Bramford to Twinstead Reinforcement

Document 8.5.3.2: Applicant's Comments on Essex County Council and Braintree District Council Local Impact Report

Final Issue A
October 2023

Planning Inspectorate Reference: EN020002

ELEVATION - B  
 SCALE 1:150

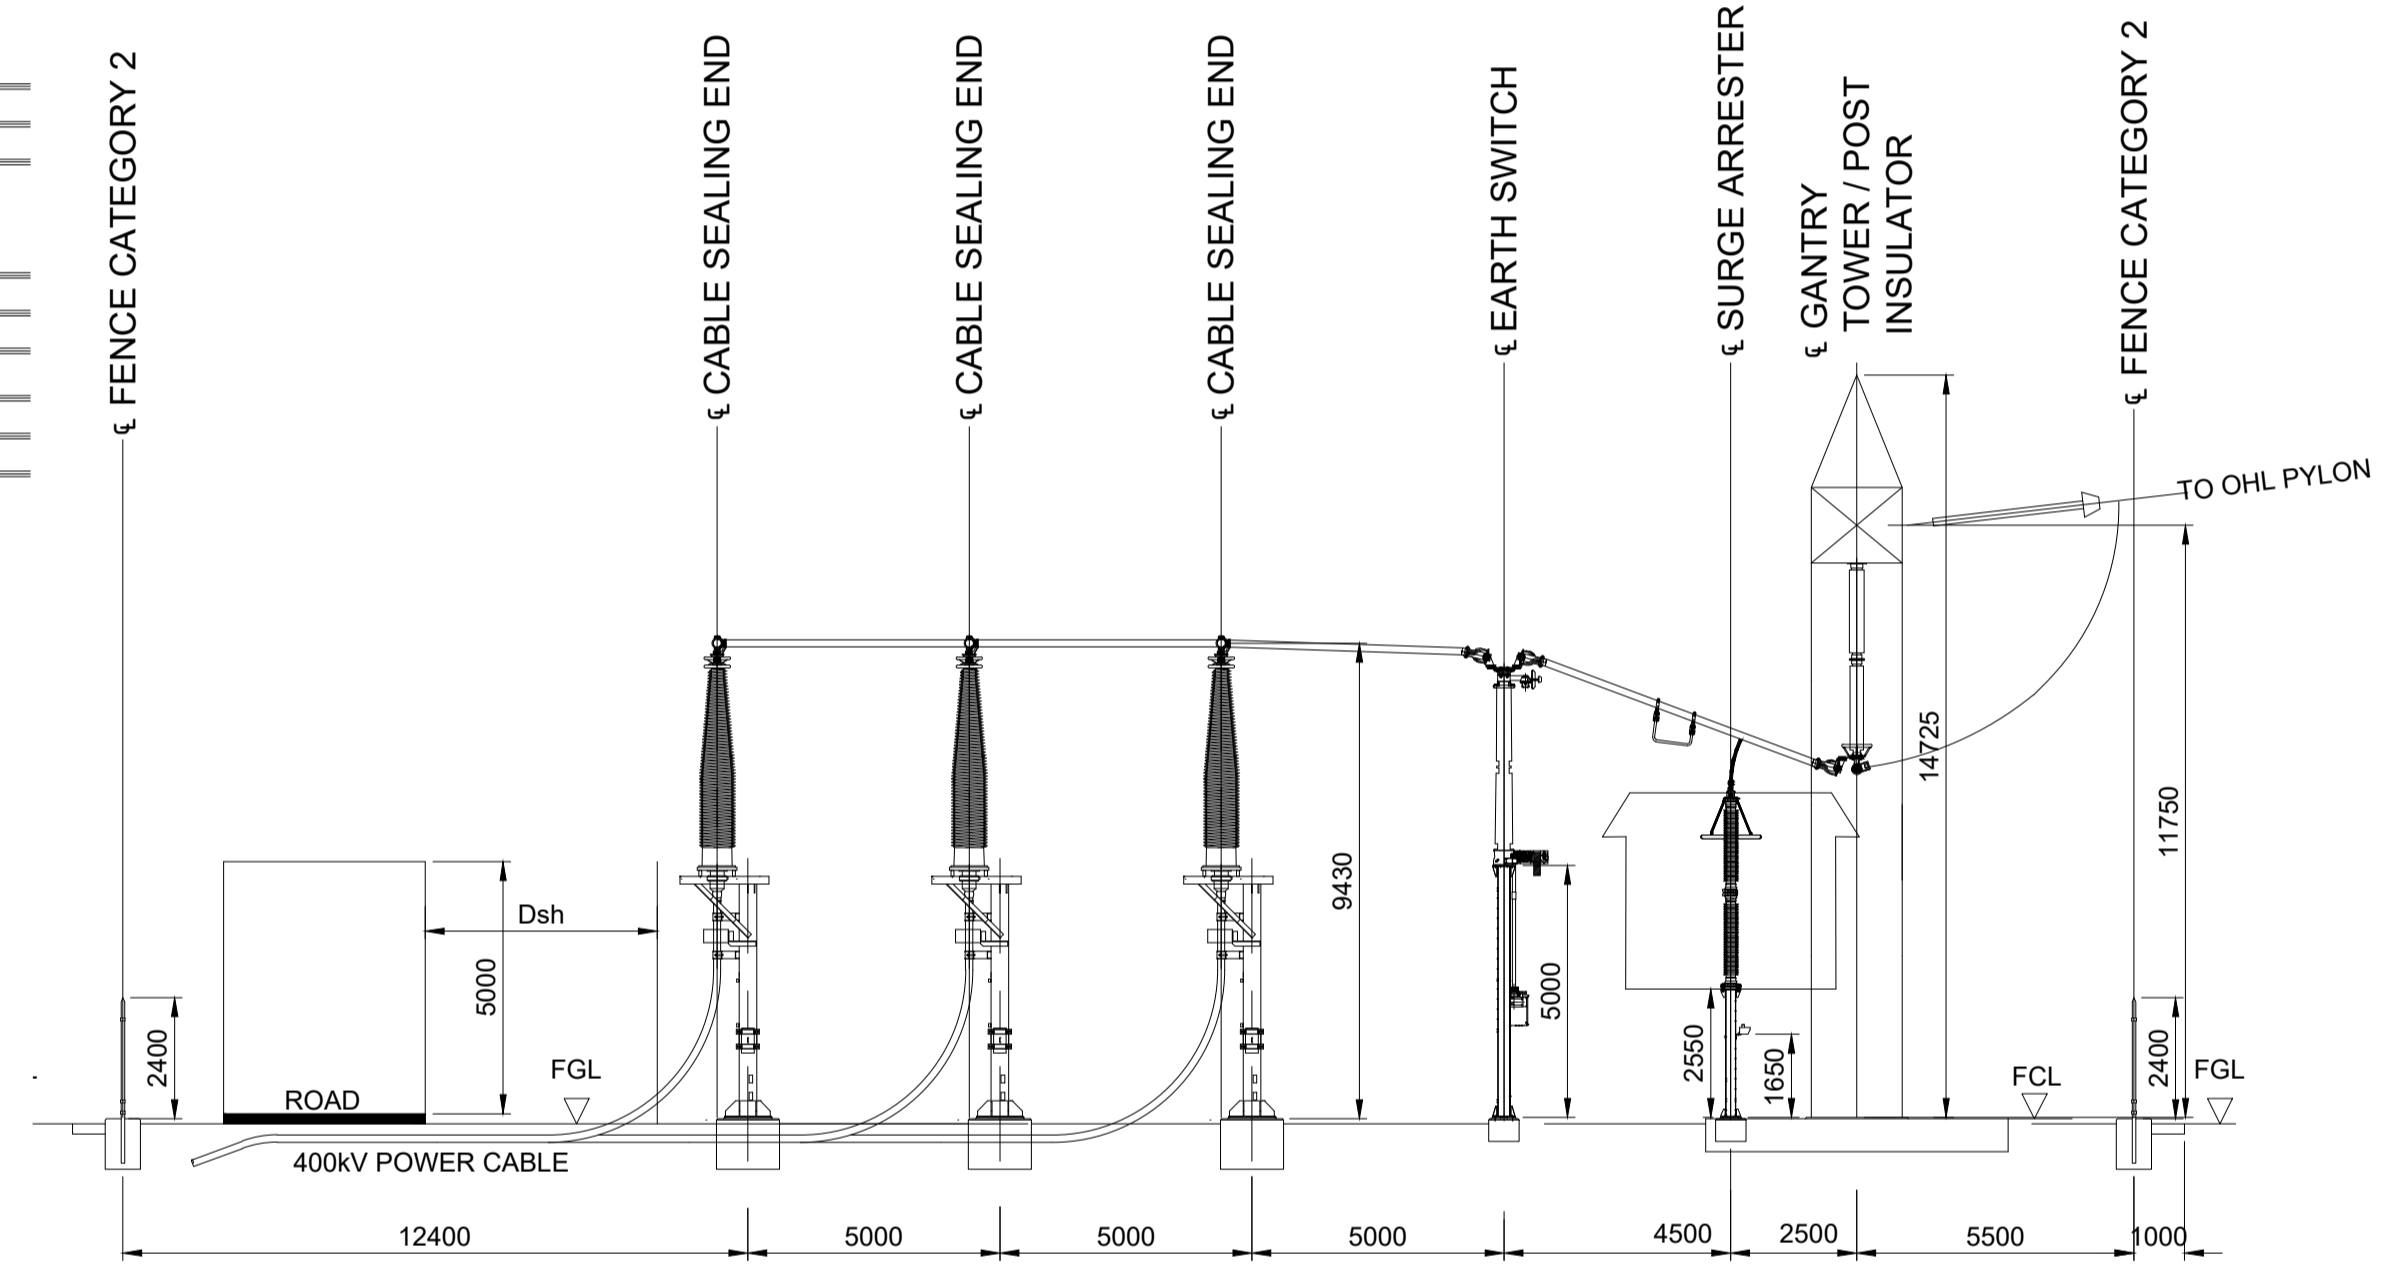
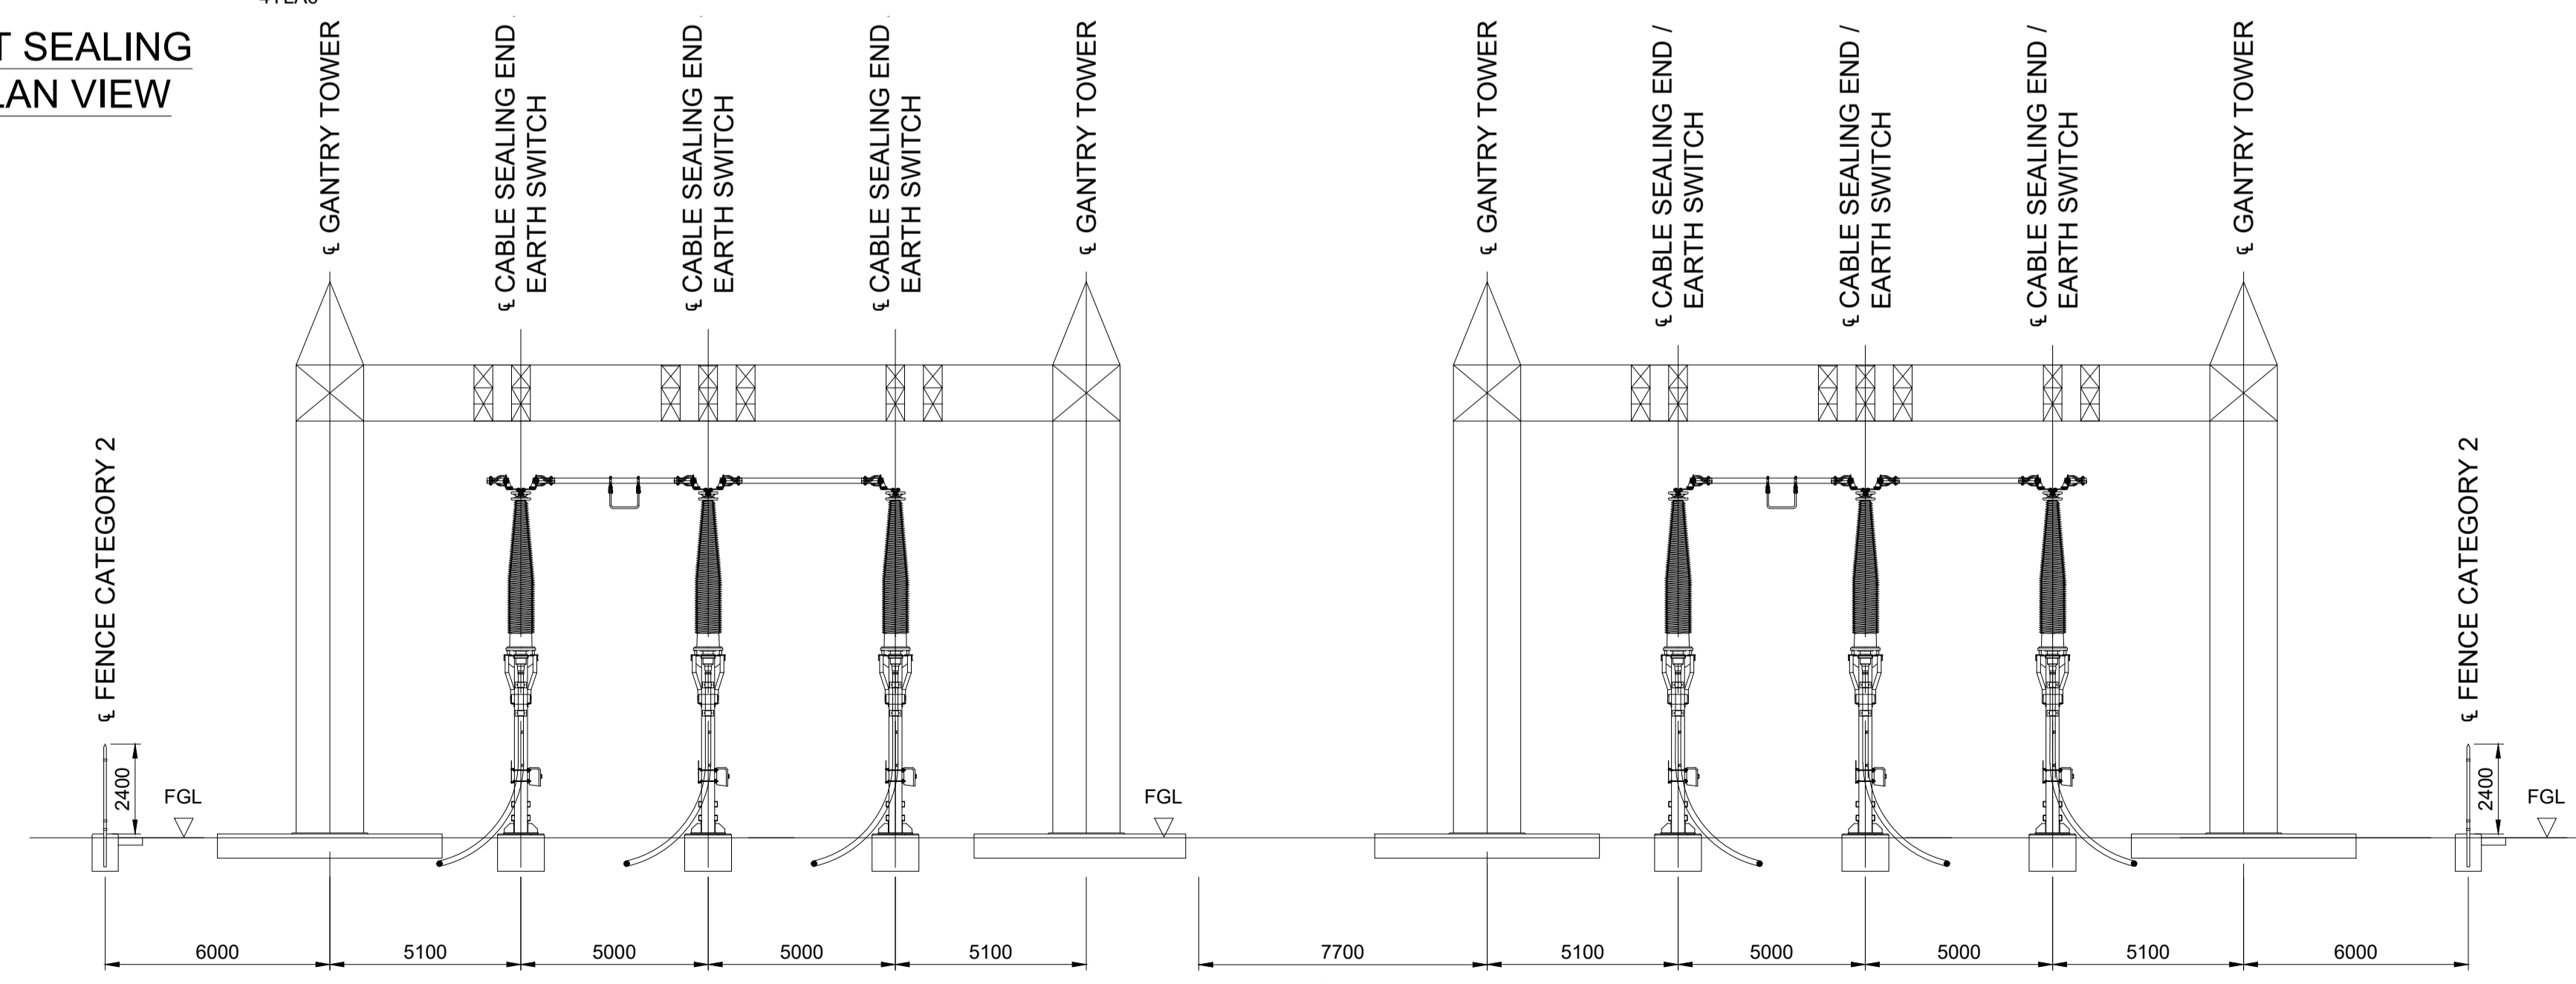
7.5.5	Construction phase impacts – Stour Valley West CSE compound (visual)	<p>The Stour Valley West Cable Sealing End (CSE) compound inserts a structure up to 11.7m high into the landscape close to a PRow. From the viewpoint Year 1 photomontage (G07 View from PRow near Mabb's Corner) the extent and nature of the planting, designed to mitigate these impacts, is unclear. Whilst removal of the 132kV cable line gives substantial landscape and visual benefits, the new structure creates an adverse impact during construction and Year 1.</p>	<p>Locations of planting for Stour Valley West CSE compound are shown in the LEMP on Sheet 28 at Appendix B Vegetation Reinstatement Plan (document 7.8.2 (B)) and planting schedules are provided at Appendix C Planting Schedules [APP-185]. Based on the average growth rates set out in Table 3.1 in Photomontages [PDA-001] it is assumed that the native trees would achieve heights up to 7.7m after 15 years. However, views from the south would remain open due to the location of the underground cables. The effects of this are shown in photomontage 34B at G-07 presented in Appendix 3 Photomontages [APP-065].</p> <p>Environmental Statement Chapter 6: ES Chapter 6: Landscape and Visual [APP-074] summarises the results of the landscape and visual impact assessment. As with any large construction project there would be some significant adverse effects during construction and in Year 1 before the vegetation establishes. However, there would also be some significant beneficial landscape and visual effects on the Stour Valley as stated in Table 6.5 of ES Chapter 6: Landscape and Visual [APP-074]. This is due to the removal of sections of the 132kV and the 400kV overhead lines in association with the proposed 400kV underground cables.</p>

7.5.9	Selected viewpoint (G07)	The Stour Valley West CSE compound at Year 15 photomontage (View from PRow near Mabb's Corner) demonstrates how limited the mitigation effect of the planting is at Year 15 with most of the structure still highly visible and the local effects still significantly adverse.	It is acknowledged at ES Appendix 6.4: Viewpoint Assessment Section G Part 6 [APP-106] that there would be a medium-small magnitude of change for receptors at Viewpoint G-07. This is because views from the south would remain open due to the location of the underground cables as shown in photomontage 34B at G-07 presented in Photomontages Appendix 3 Photomontages [APP-065]. Operational safety restrictions mean that only low rooting species can be planted over the cables so that roots do not interfere with the operation of the cable system.
